CITY OF ALBUQUERQUE

February 5th, 2020

Re: Barlow Shop
6205 Wilshire Ave NE
Traffic Circulation Layout
Engineer's/Architect's Stamp 12-11-19 (C18D070)

Site Plan

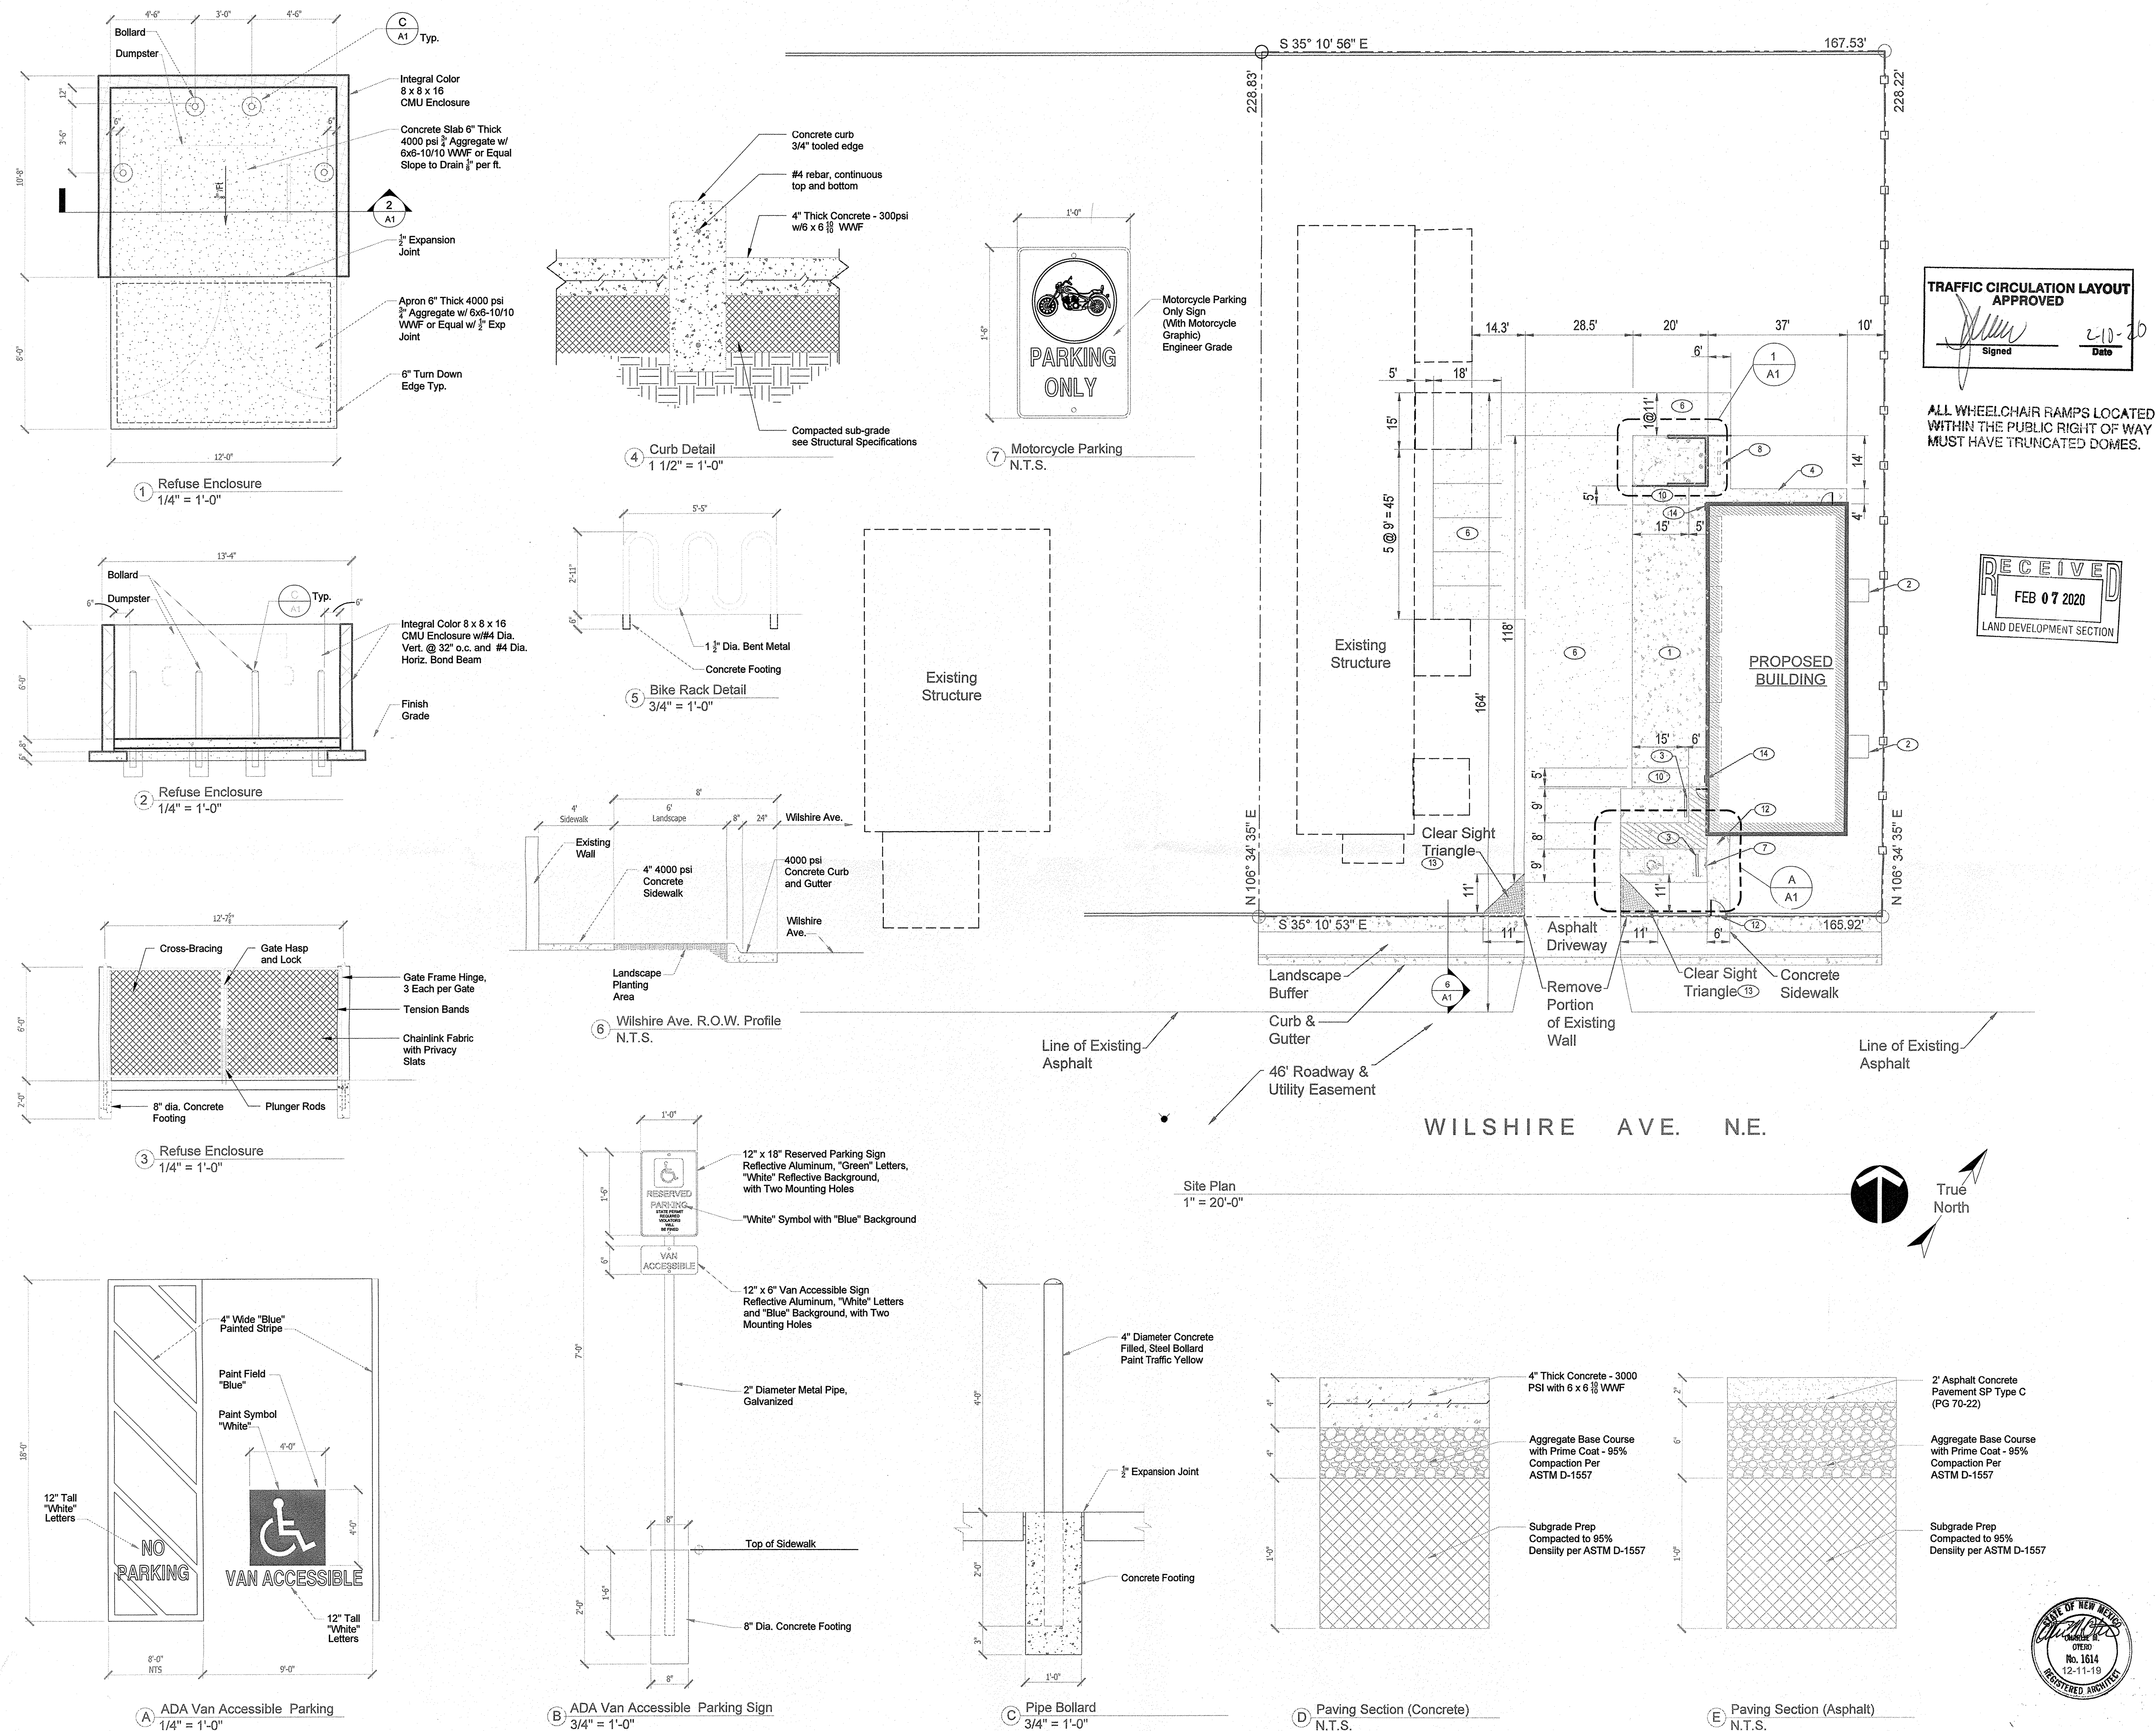
1. Please remove clouds on TCL Plan.
2. Please relocate Bike Rack, not allowed within parking stall.
3. All bicycle racks shall be designed according to the following guidelines:

- a. The rack shall be a minimum 30 inches tall and 18 inches wide.
 - b. The bicycle frame shall be supported horizontally at two or more places. Comb/toaster racks are not allowed.

- c. The rack shall be designed to support the bicycle in an upright position. See the IDO for additional information.
 - d. The rack allows varying bicycle frame sizes and styles to be attached.

- e. The user is not required to lift the bicycle onto the bicycle rack.
 - f. Each bicycle parking space is accessible without moving another bicycle.

4. Bicycle racks shall be sturdy and anchored to a concrete pad.
5. A 1-foot clear zone around the bicycle parking stall shall be provided.
6. Bicycle parking spaces shall be at least 6 feet long and 2 feet wide.
